35 Ind. Way
Bld. Expansion
Future Holdings

RE: North Atlantic Scaffolding Expansion, 35 Industrial Way
ID #2003-0163, CBL #327A-A-007

RE: 35 Industrial Way –North Atlantic Scaffolding Expansion

I have reviewed the submitted Site Plan and Documents for 35 Industrial Way, North Atlantic Scaffolding Expansion and have the following comments:

Job No. 4105 Sheet 2 of 3	SITE LAYOUT, GRADING & DRAINAGE PLAN	Designed TPO Drawn TPO Checked DAK Scale 1" = 20' Date 8-8-03	Revision 1. 8-8-03 2. 8-8-03 3. 8-8-03	PROPERTY OF: N. ATLANTIC SCAFFOLDING 35 INDUSTRIAL WAY PORTLAND, MAINE 04103

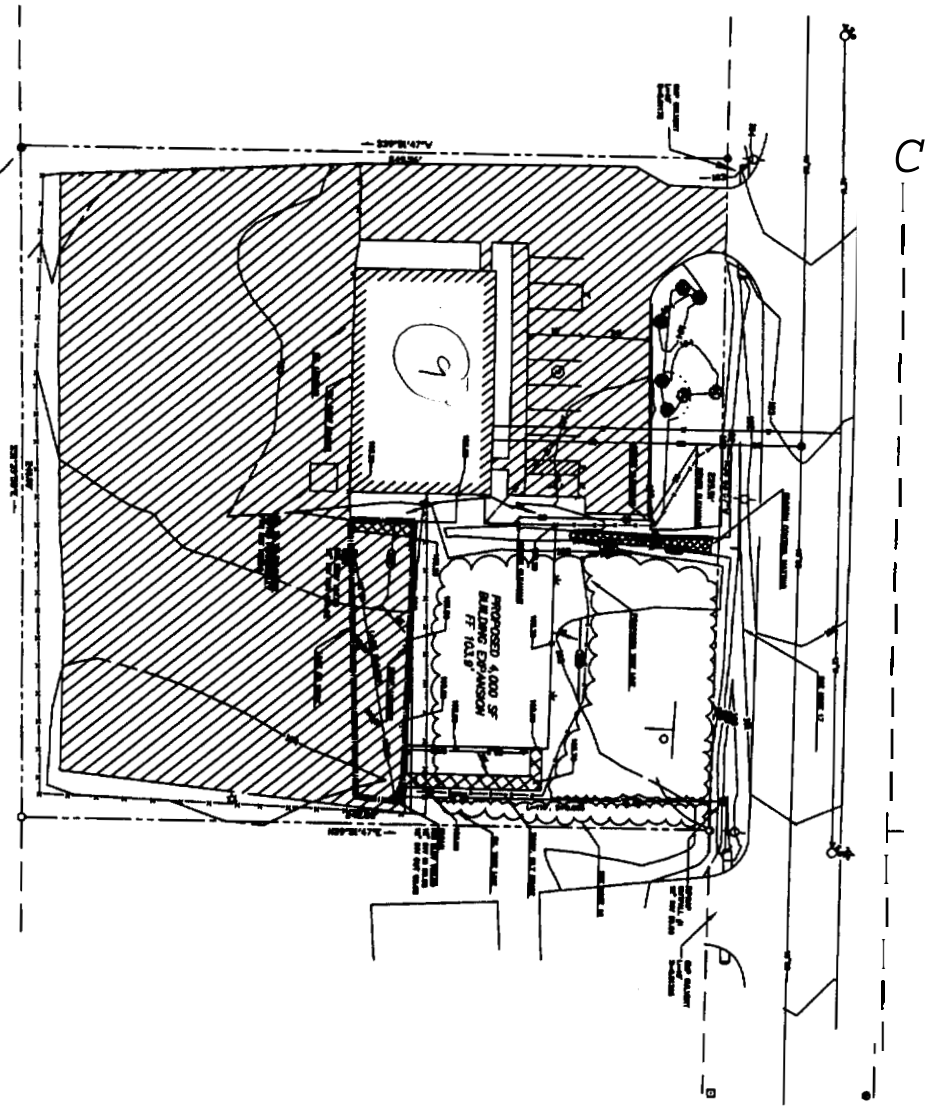
1. I have reviewed the **Site Layout, Grading and Drainage Plan, Sheet 2 of 3** and have a few minor comments regarding some of the drainage provisions and parking lot layout.

- A. The 12 inch storm drain at the entrance on the east side is very limited in pipe slope. The City does not typically allow slopes less than 0.005 ft/ft. It appears that the cover on some of the pipe is less than 18 inches. Given the difficult outlet elevations, the cover issue may not be correctable. However, if CB #1 is shifted east a little and the rim grade raised 3 inches, and the storm outlet dropped 6 inches to match the ditch elevation 99.0, then the drain slope could approach 0.005 ft/ft.

- B. The ditch along the middle of the lot should be widened/reshaped and stabilized with the Armour matting. Also, the existing roadside ditch shall be cleaned of debris and sediment during construction to assure proper drainage to the culvert to the driveway on Lot 3. Most important is that the culvert near the entrance to Lot 3 (in the right-of-way) has a sump and is unrestricted.

- C. Spot grades shall be shown around the footprint of the existing building, the new structure, and proposed walkways to assure that drainage will be properly diverted away from the structure. If necessary, please show either new grades or drainage arrows with intended slope away from the structure.

- D. All parking areas to include handicapped accessible areas shall be delineated on the plan. All parking dimensions and aisle widths shall meet City specifications.

- E. The section of parking lot where the storm drain will cross will need to be replaced. Please indicate new limits and grading of these paved areas.

- F. Is it necessary to connect a separate water service and open the street, or can the current service be split at the property line and also service the new addition? This would appear to save costs and construction disturbance. Regardless, letters of available capacity are needed from the Sewer Division and Portland Water District.

- G. The buffer between the proposed storm drain and Lot 3 is relatively thin; as much of the buffer as possible shall be kept in its natural state. If the area is eliminated during construction, then the area shall be replanted with an acceptable screen of trees such as Arborvitae, Cedar, Maple, or plantings tolerating wet soils. Please confer with the City Arborist during construction regarding trees to save or new plantings selected.

- H. Silt fencing shall wrap around the front end of the parking lot where soil disturbance for sewer connections occurs next to the existing swale and road ditch.

- In response to comment 1A, the outfall for the proposed storm drain pipe into the ditch has been lowered to elevation 99. This will allow us to raise the slope on the system to approach 0.005. In addition, by lowering the outfall, we were able to provide 21" to 36" of cover over the proposed system.
- In response to comment 1B, we have widened and regraded the ditch along the middle of the lot and added an additional note pertaining to cleaning debris and sediment from the existing roadside ditch to ensure proper drainage.

- In response to comment 1C, we have added spot grades around the proposed building and put drainage arrows depicting the flow patterns away from the proposed building.

- In response to comment 1D, we have added a striping plan for the existing parking spaces along the front of the existing building. We have depicted handicapped parking areas and shown dimensions for the parking spaces.

- In response to comment 1E, we have indicated the work limits for the work associated with installing the proposed storm drain and revised the grading in these paved areas.

- In response to comment 1F, we have sent letters to the Portland Water District and the Portland Engineering Division requesting ability to serve letters for the project. We have included these letters along with this submission. We will provide, separately, the ability to serve letters as soon as we receive them. We have also contacted the Portland Water District and the Portland Engineering Division in regards to the project and notified them no new employees will be added and we will not be introducing additional flows for the project.

- In response to comment 1G we have added an additional note to the plans for the contractor to preserve, to the extent possible, the tree buffer between lot 3 and the proposed storm drain and to contact the city arborist during construction regarding trees to save or new trees to be planted.

- In response to comment 1H, we have added areas of additional silt fence around the front of the existing parking lot adjacent to the existing swale and the roadside ditch.
